## KVFR Prevention Conditional Use Permit Comments

Project: Brick House Nursery Event Center

Permit#: CU-22-00004

Date: 12/06/2022

**SITE PLAN 11x17
EVENT USE**

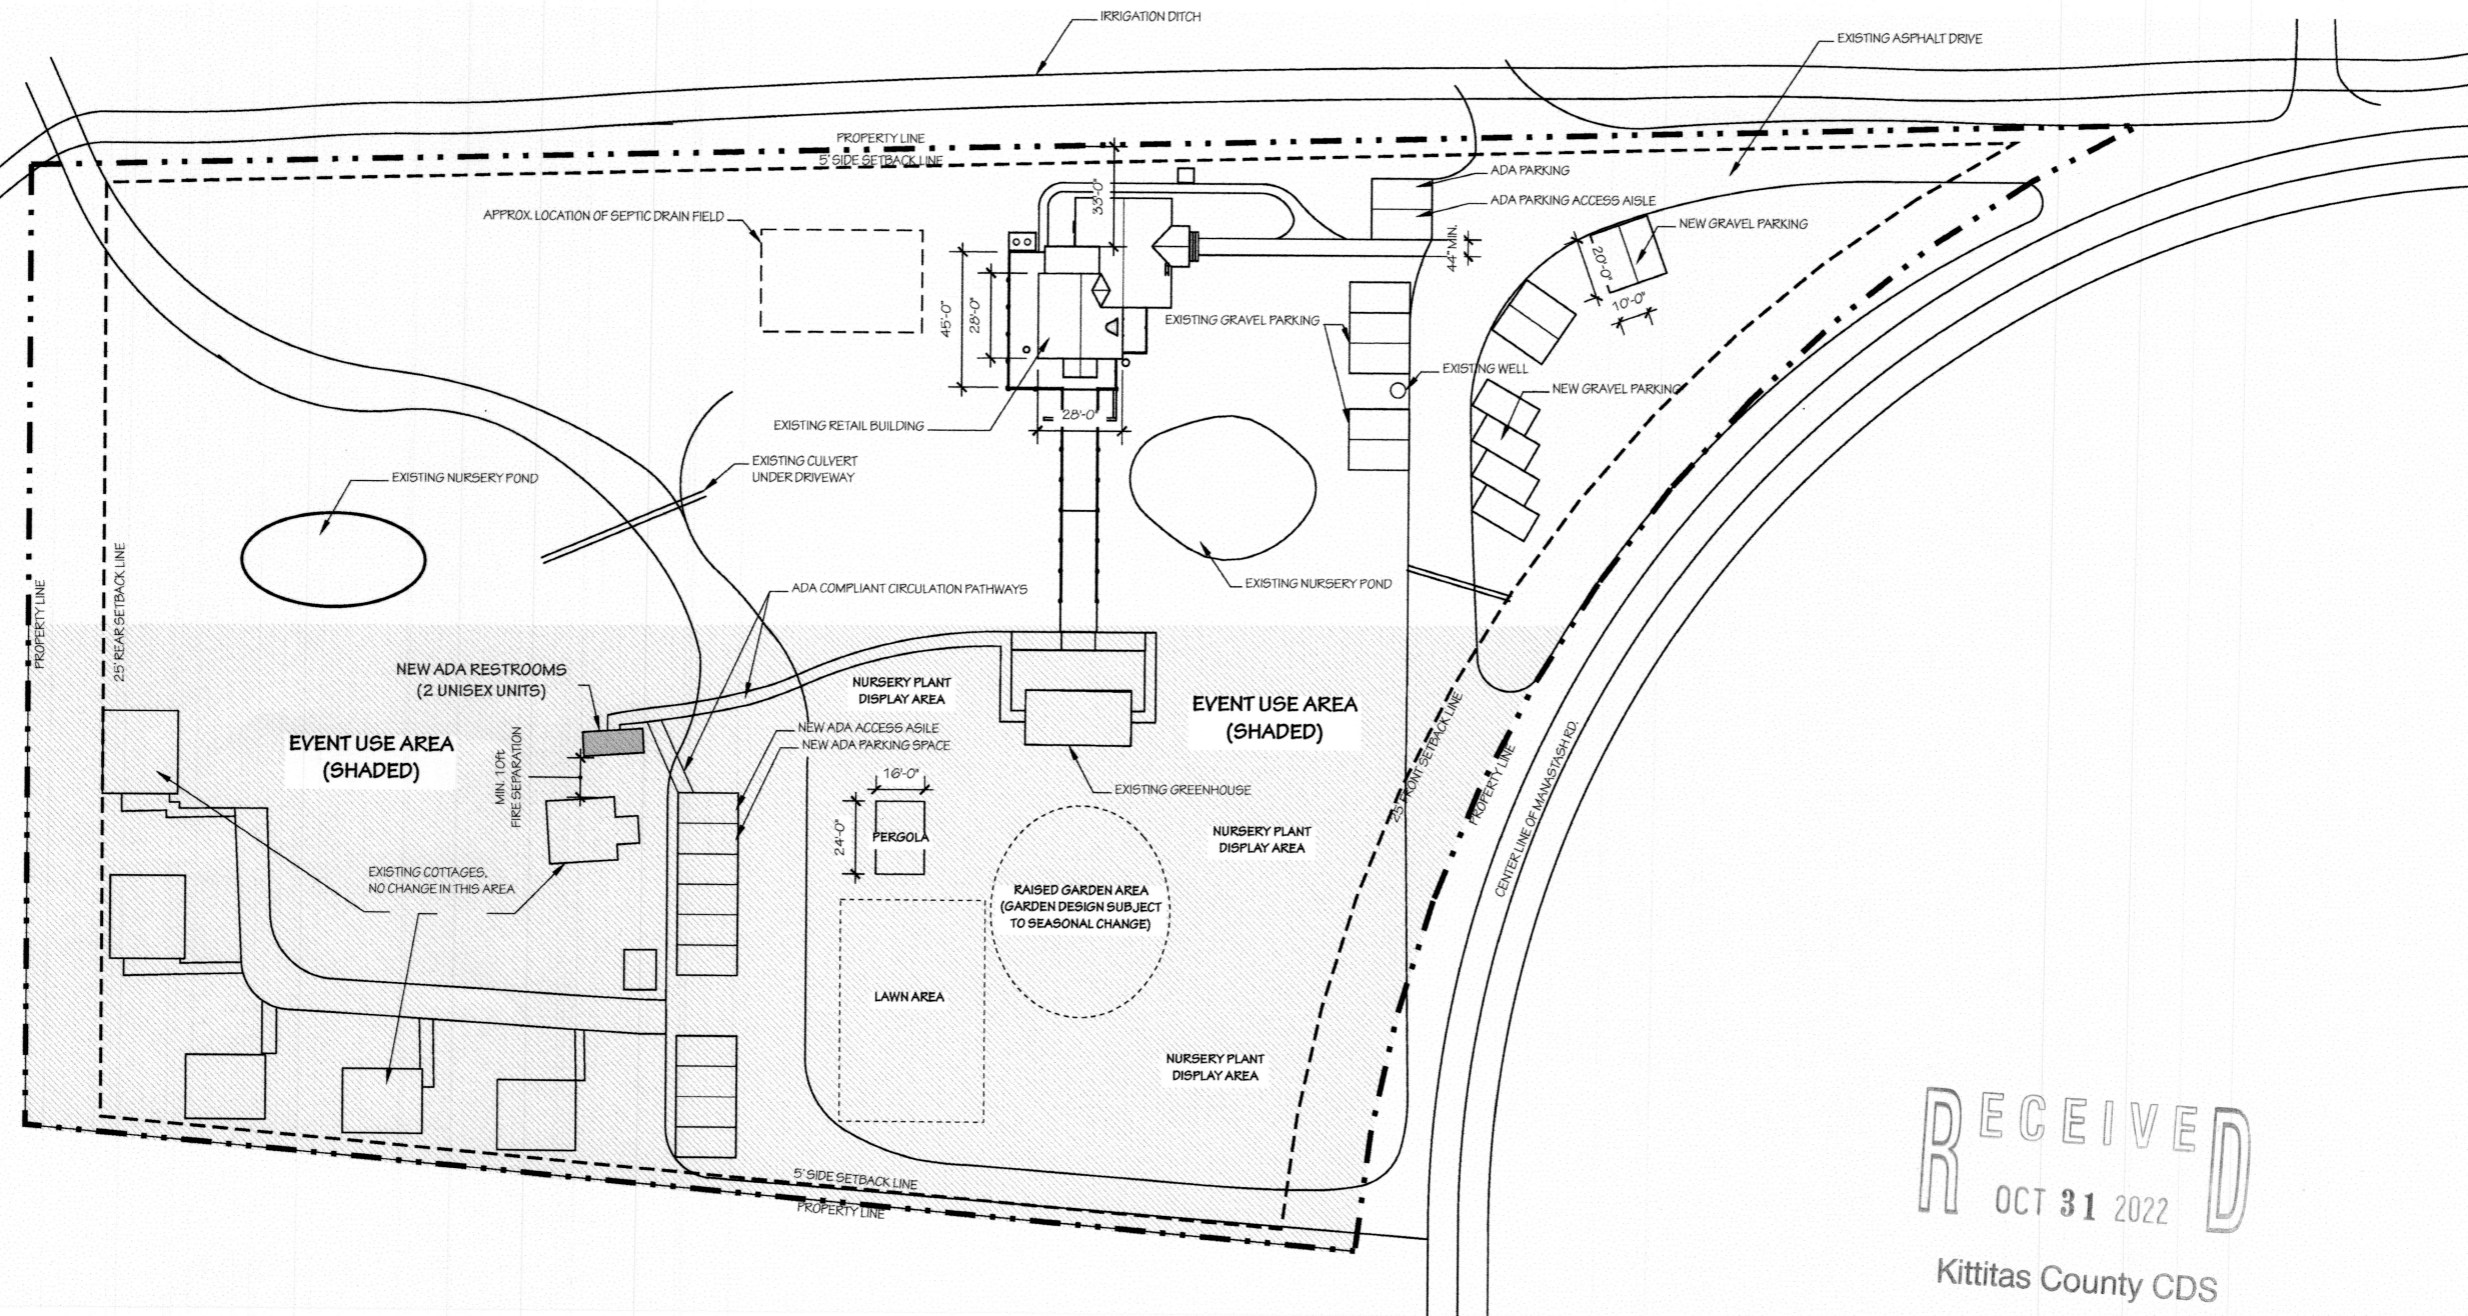
- Fire apparatus access roads exceeding 150' shall be provided with a temporary or permanent turnaround meeting the requirement 2018 IFC Appendix D. This does not appear to be met for the associated proposed area or use.
- Sufficient parking, based on occupancy and to not interfere with fire lanes and building access.
- The IFC Appendix D requires the road be a minimum of 20' wide and capable of supporting an imposed load of at least 75,000 lbs.
- Buildings would be required to meet current IBC, IFC, WUI, requirements due to the change in use for the commercial occupancy. This may include fire sprinklers, fire alarm, exiting, emergency lighting, etc. This cannot be determined without more specific information.
- Our standard turning radius is a minimum of 23' inside and 45' outside.
- Water supply meeting Kittitas County requirements.
